From: Geoff [REDACTED]
Sent: 02 July 2019 09:29
To: [REDACTED]
Subject: Applications AB/48/19/PL and AB/49/19/L

Further to our email of 27th June I write in order to submit the following revised drawings:

Please accept the above drawings as amendments to applications AB/48/19/PL and AB/49/19/L

A6001-03A

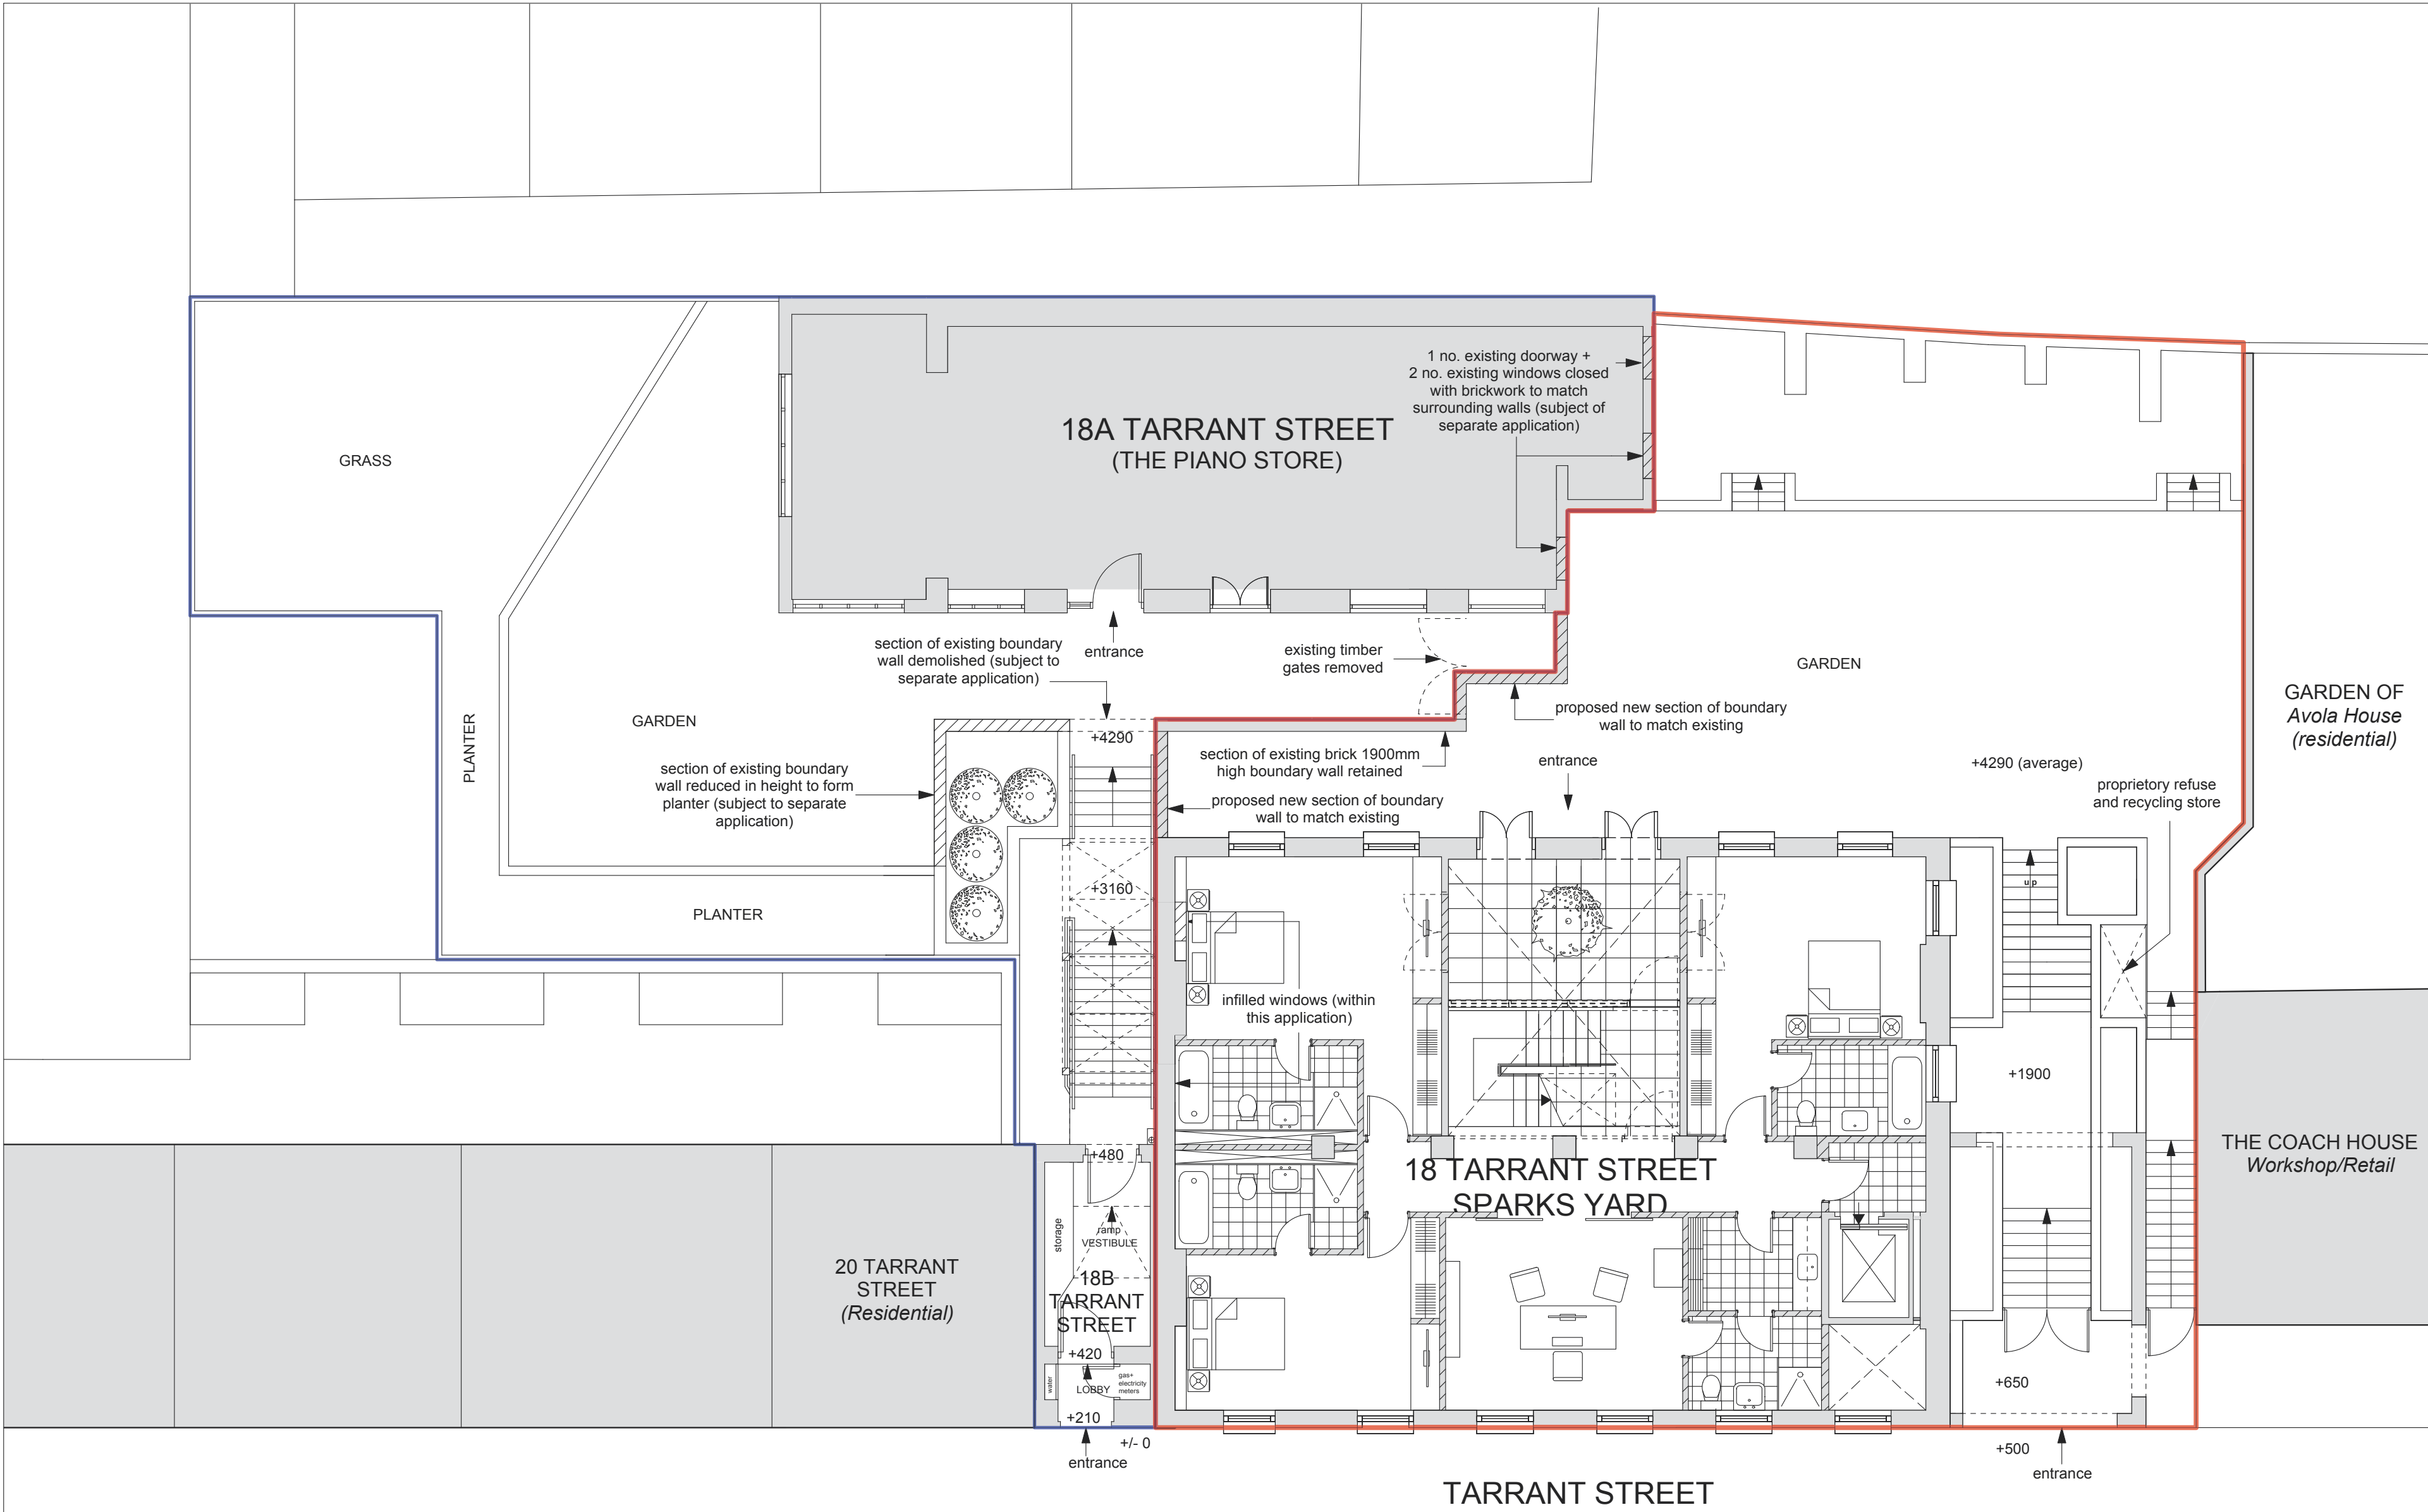
Drawing A6002-03 Revision A

This drawing is revised to show further information/clarification regarding the proposed revisions to the existing boundary wall between the application site and the adjacent 18A Tarrant Street.

A6001-05A

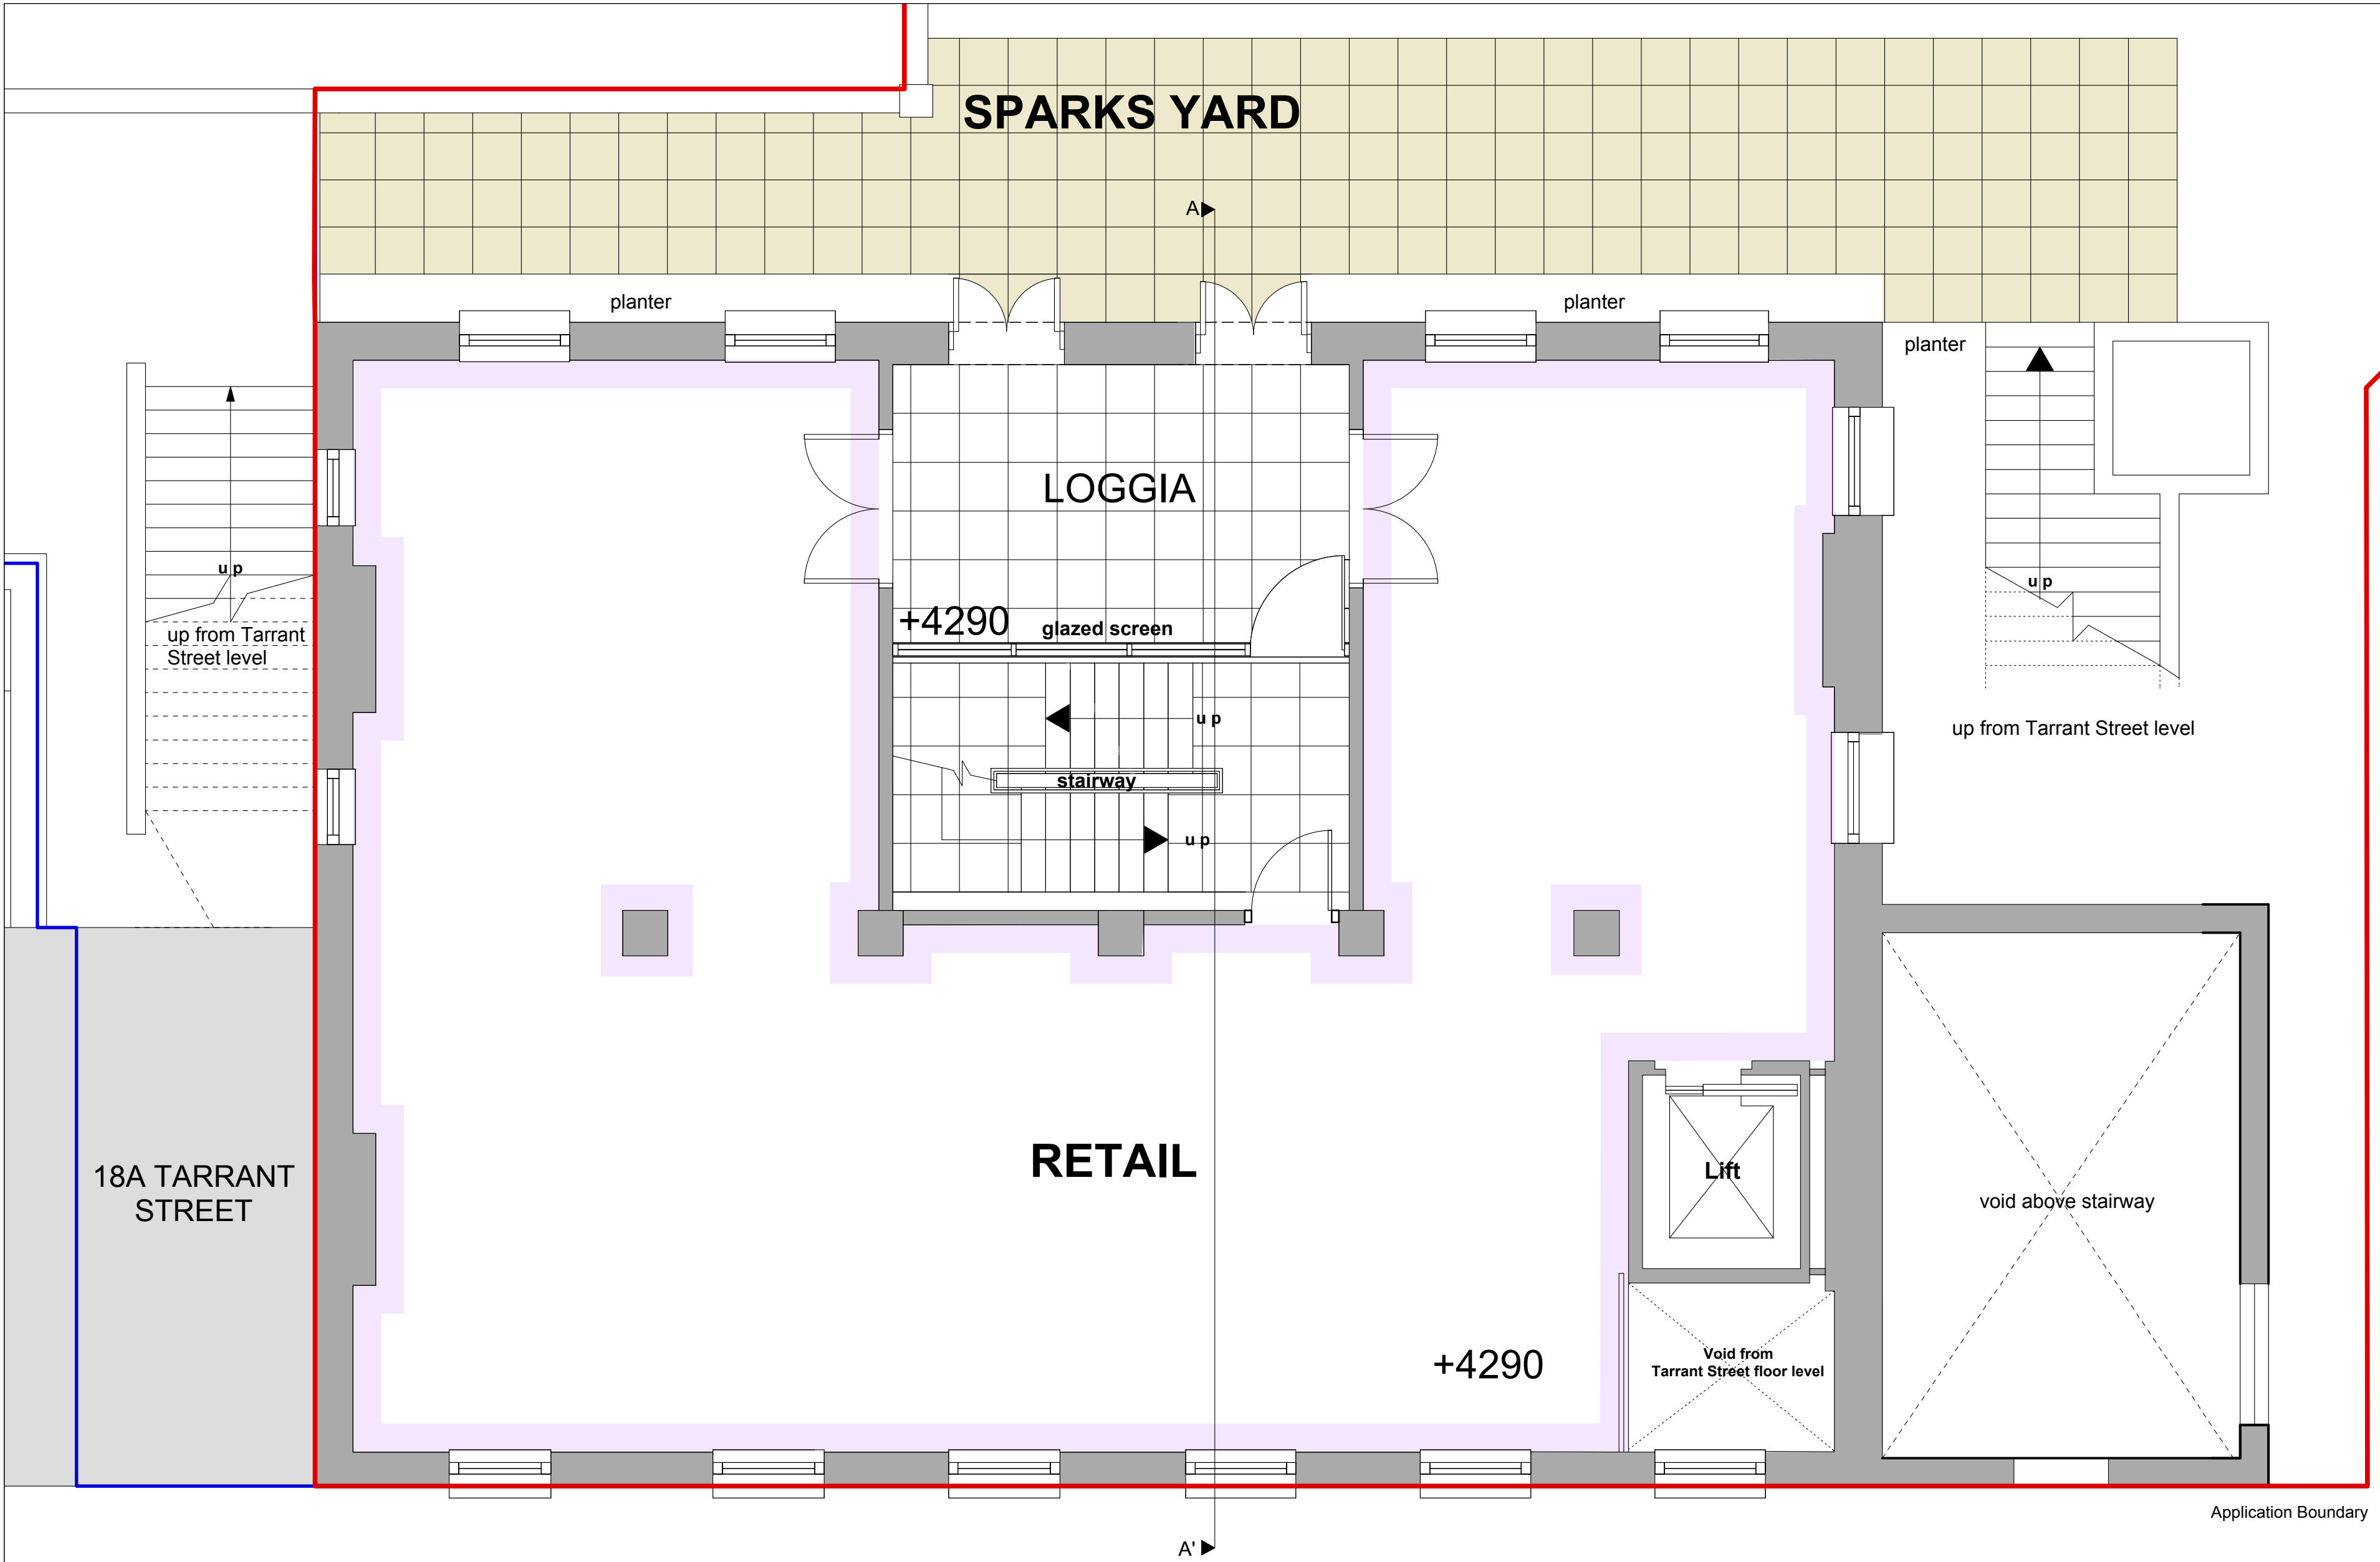
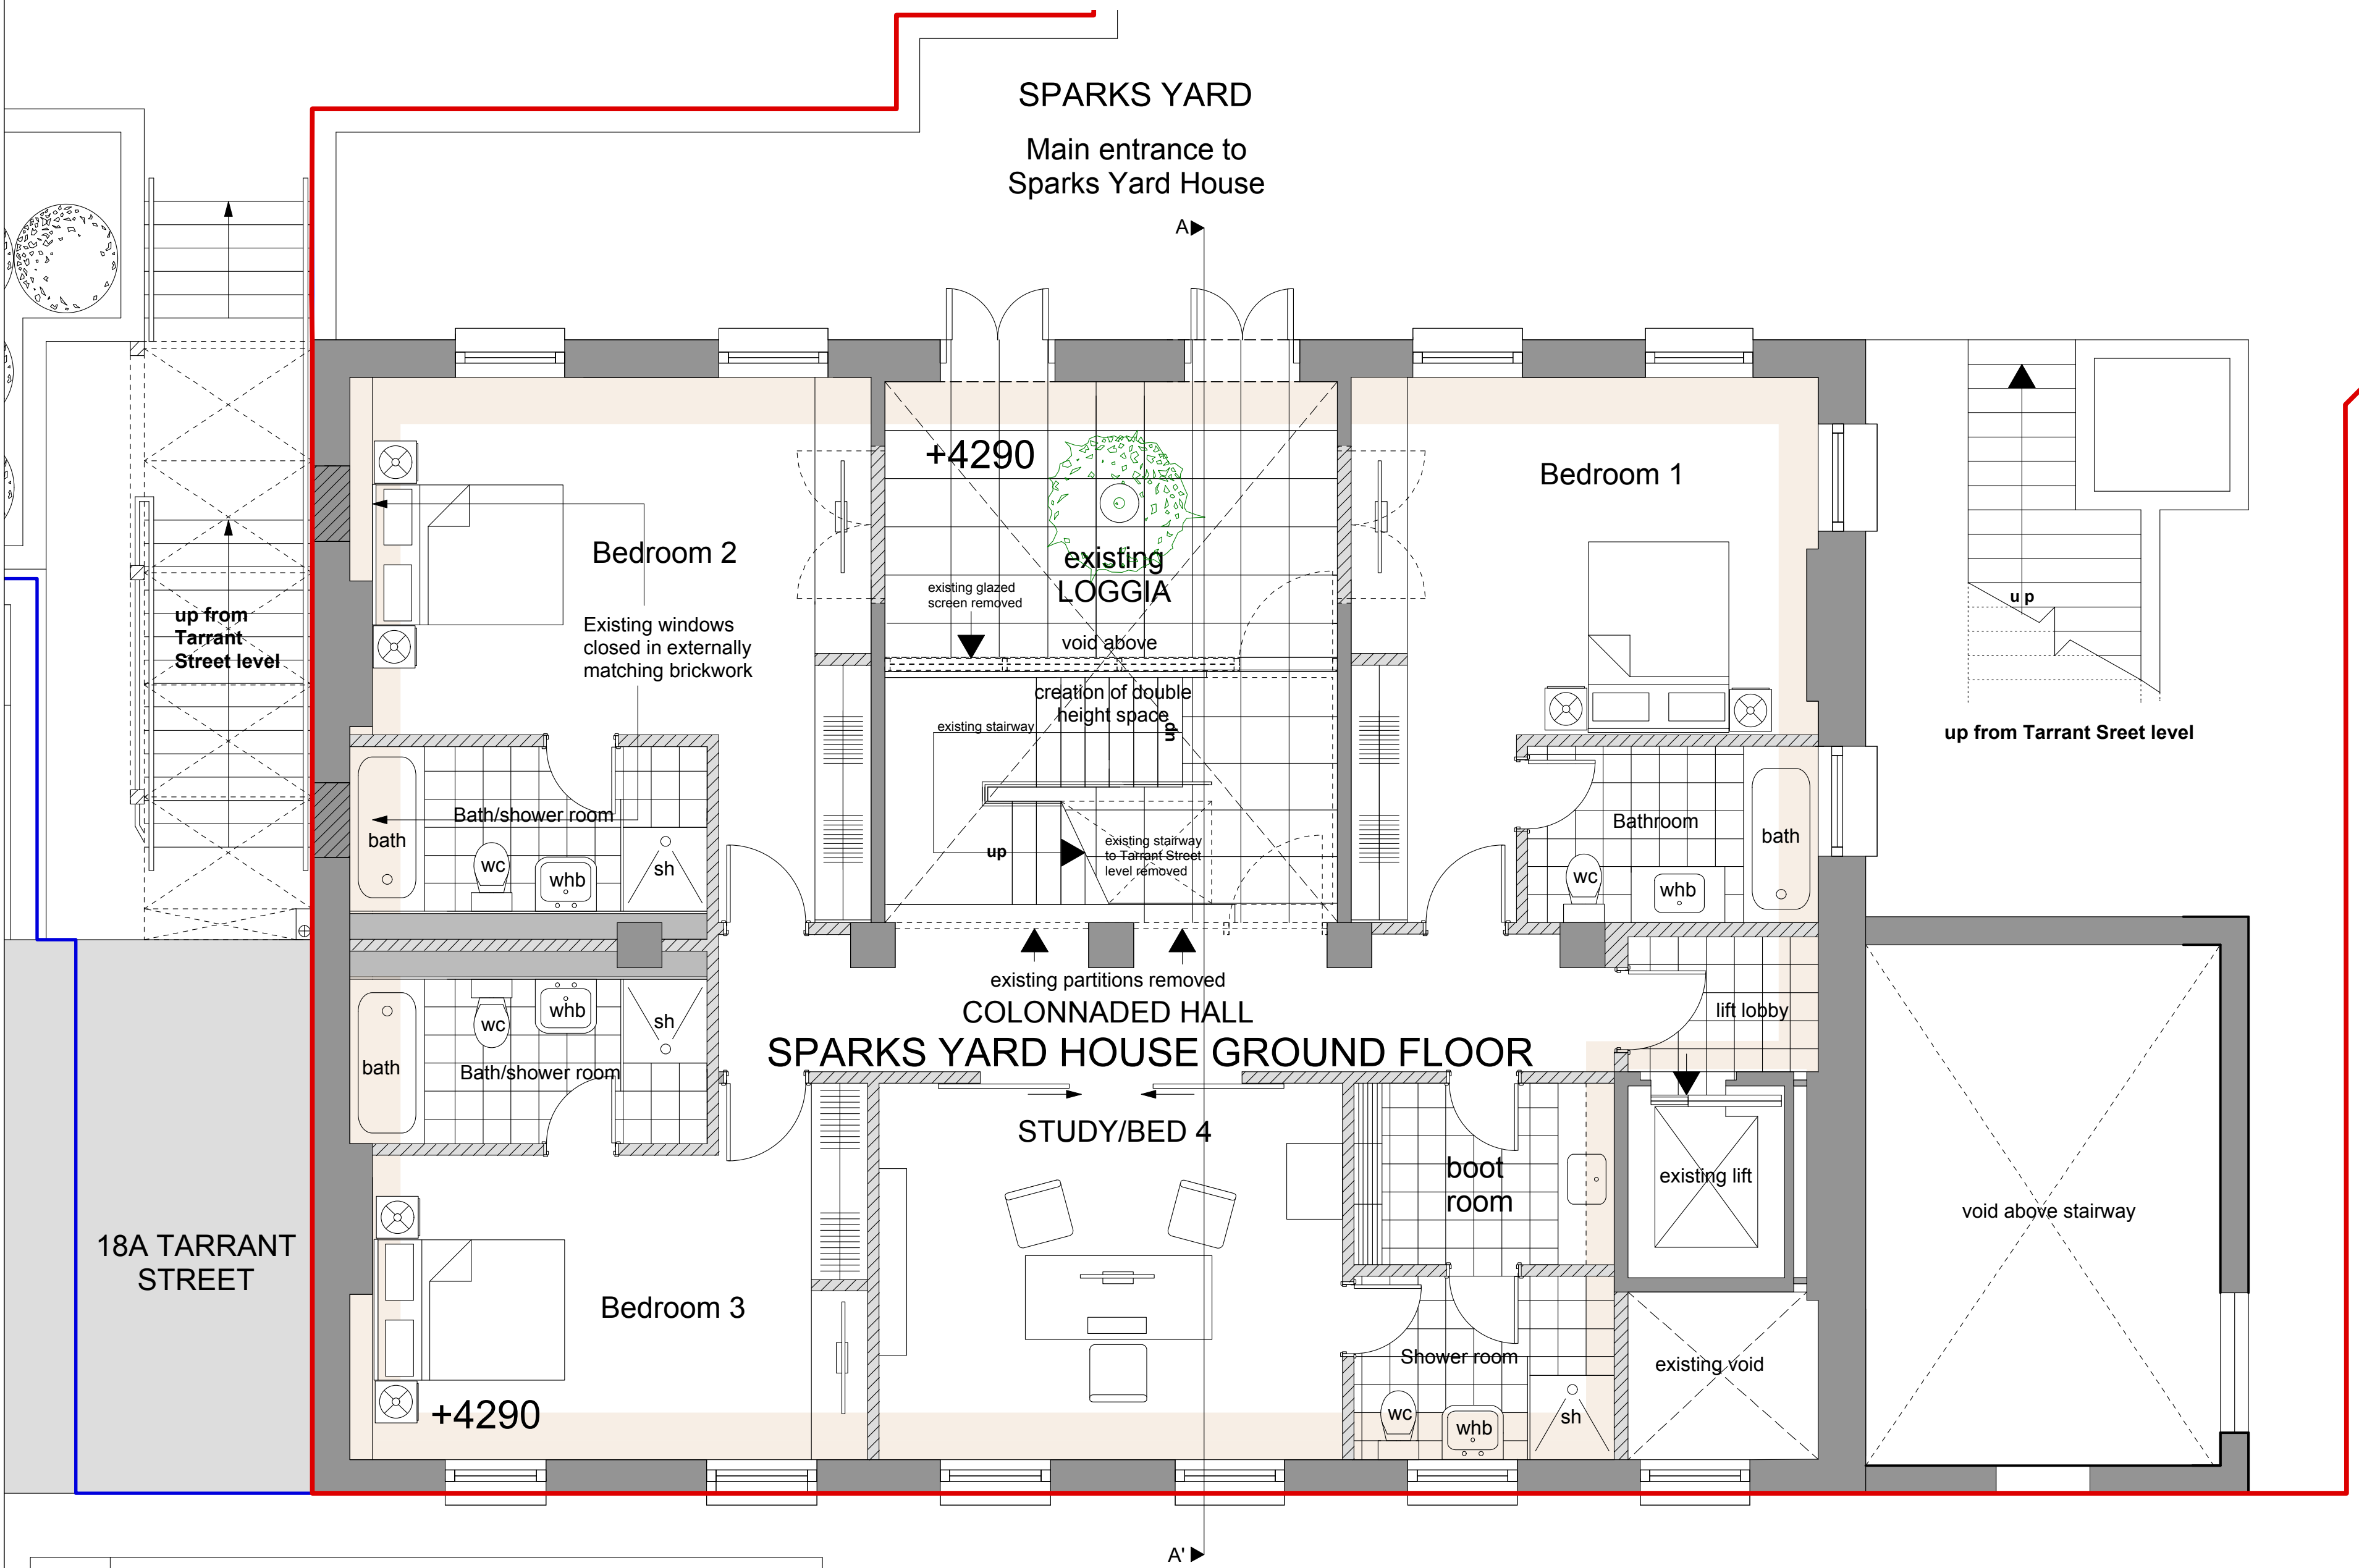
Drawings A6002 -05 Revision A, -06 Revision A and -08 Revision A.

All three drawings are revised, removing the previously proposed plasterboard faced, insulated internal wall linings to the upper two floors of the building.
